**CITY OF PORTLAND, MAINE  
DEVELOPMENT REVIEW APPLICATION  
PLANNING DEPARTMENT PROCESSING FORM  
DRC Copy**

Single Family Home / split lot  
Project Name/Description

September 6, 2006

RE: Application for single family house, 82 Belfort Street

**LAYOUT PLAN**

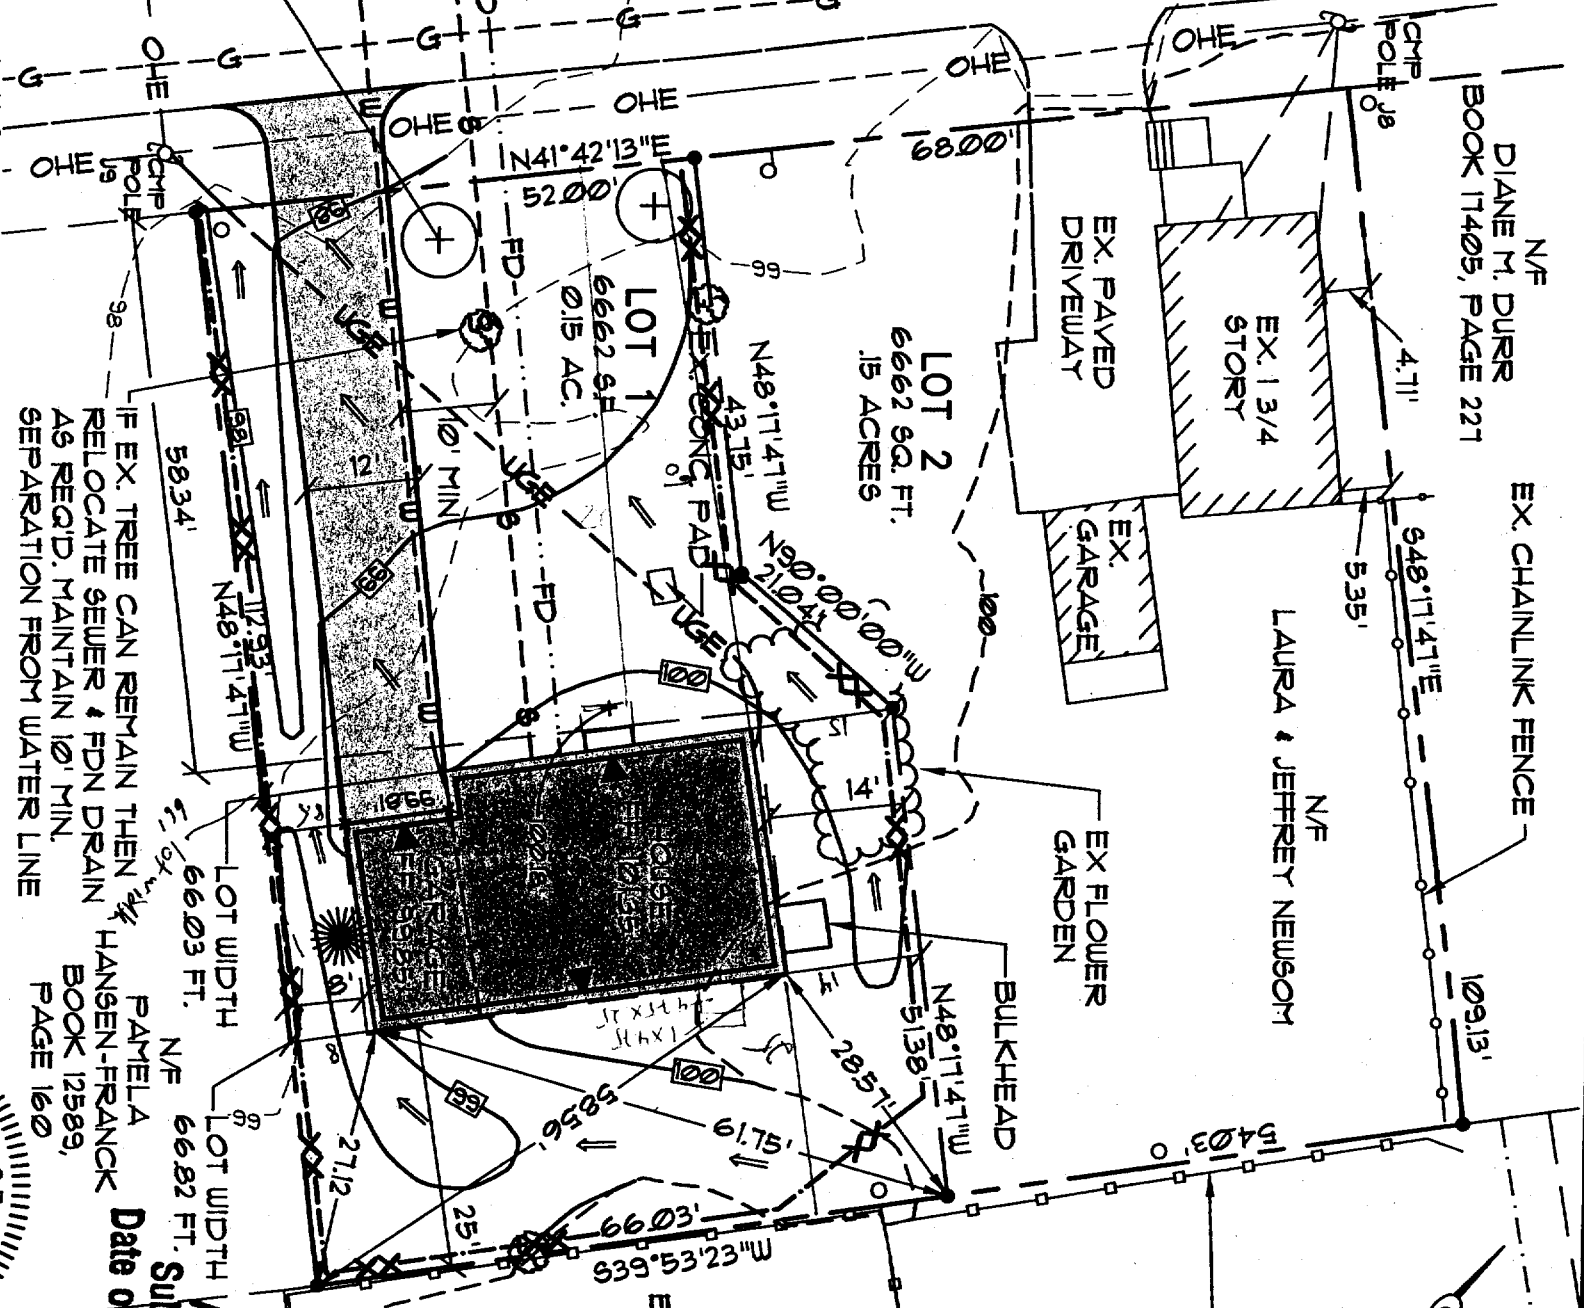
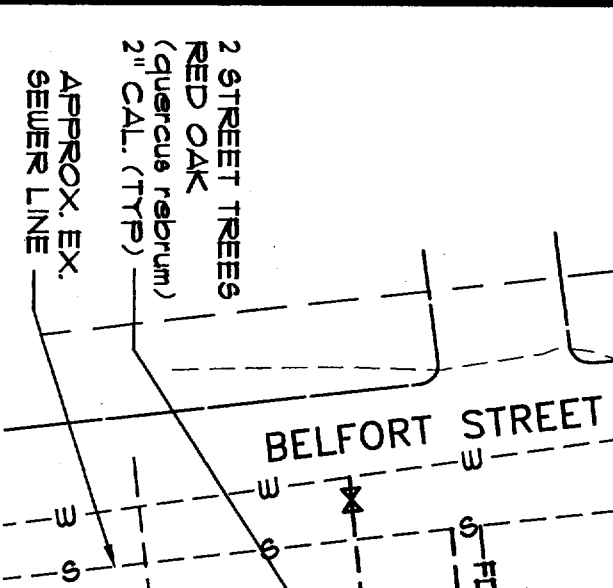
1. The proposed topography appears to be channeled and directed onto the neighboring property. It is a requirement that development does not affect neighboring properties with increased drainage. Please redesign as needed.

I hereby request amending my approved Site Plan for the new home I built at 88 Belfort Street to reflect installing a 15" retaining wall in place of a swale along the right side of the property per the Pinkham & Greer September 12, 2006 Layout Plan.

The split faced landscape block wall, installed just inside the right side property line, commences 21' from the rear boundary line and runs a total of 48'. The wall prevents water from draining to the abutter, Pamela Larsen, 96 Belfort Street. The swale will not perform any better than the wall does now.
